**Re: Winter Green Apartments – 10932 Golf Course Rd NW.
ESC Plan Engineers Stamp Date: 6/8/2021 – A12E008D**

Based upon the information provided in your submittal received on 6/8/2021, the above-referenced ESC Plan can't be approved until the following additional information is provided.

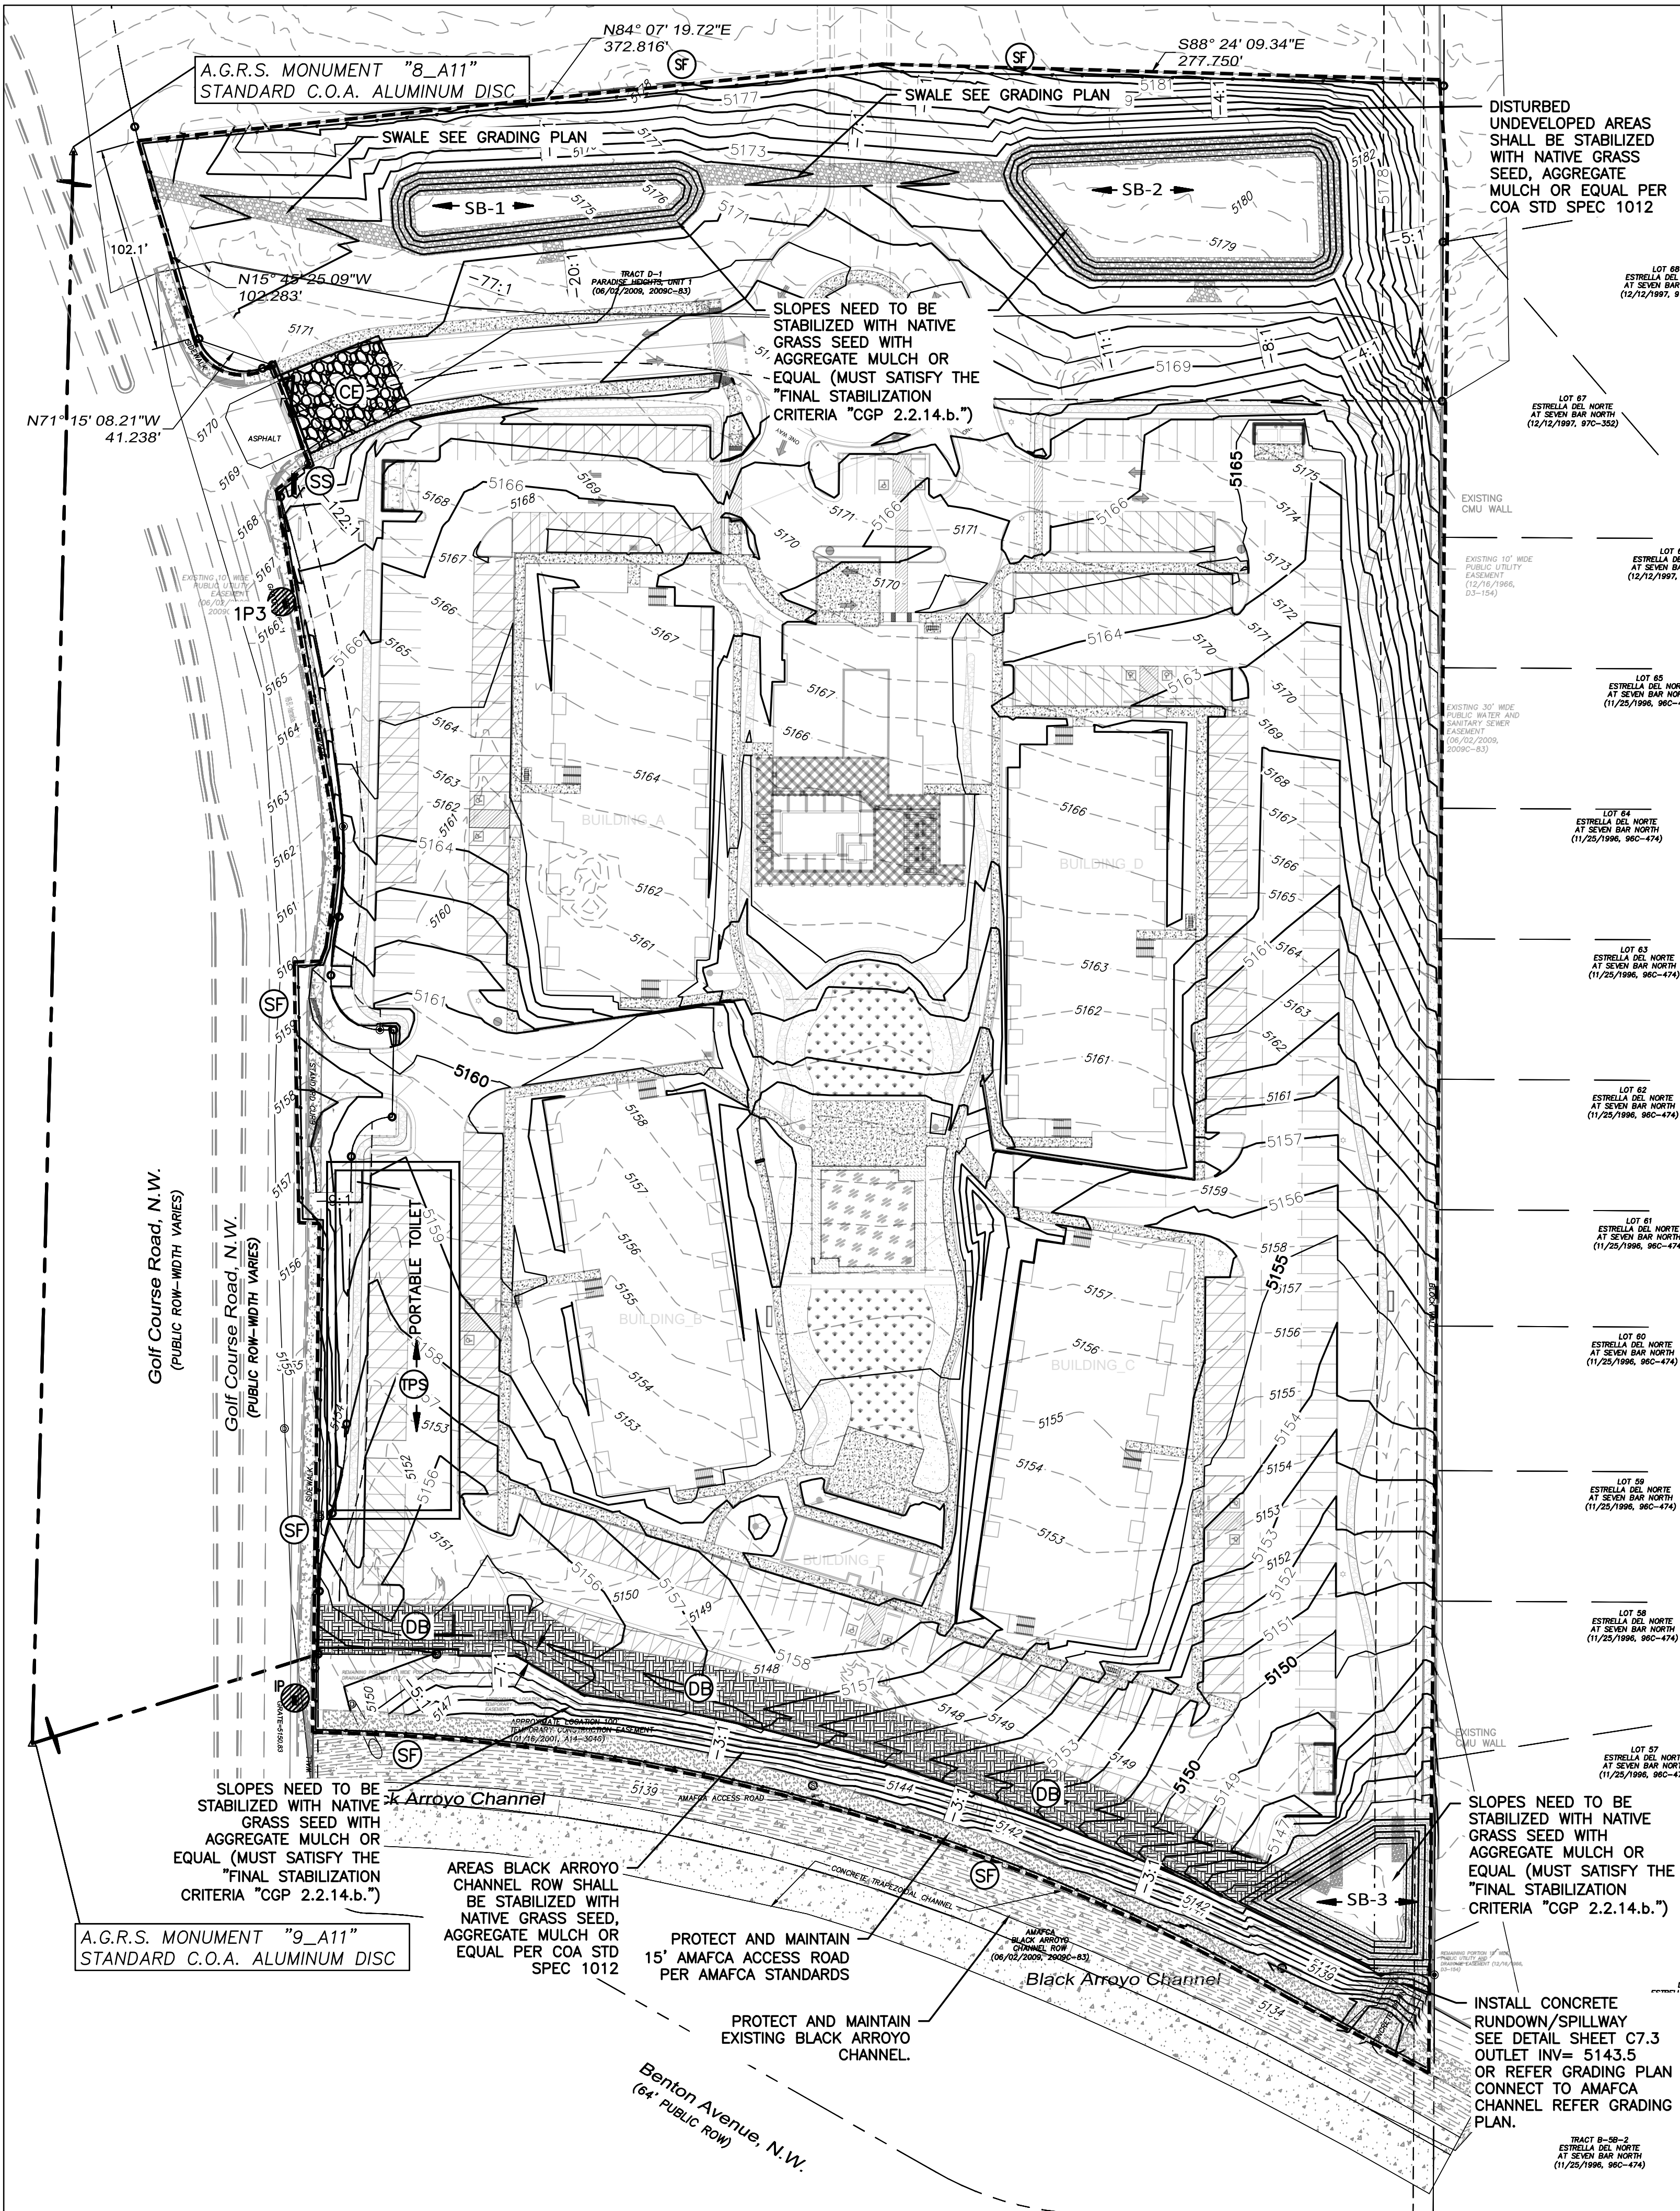
1. Better temporary erosion and sediment controls are needed to prevent drainage on the steep slope next to the Black Arroyo channel. The drainage from this site should be diverted into the southeast sediment basin by a diversion berm located at the top of the slope. The Sediment Basin calculations should be added the plan. The required temporary volume may need to be more than the permanent pond volume. The sediment basin should retain the 2-year volume and discharge excess through a non-erosive primary piped outlet. A non-erosive 100-year overflow (Concrete) should also be constructed before any of the rest of the land-disturbing activities begin.

stabilizing the steep slope next to the Blacks arroyo, such as the NMDOT specifications for seed and rock mulch, must be added to the plans.
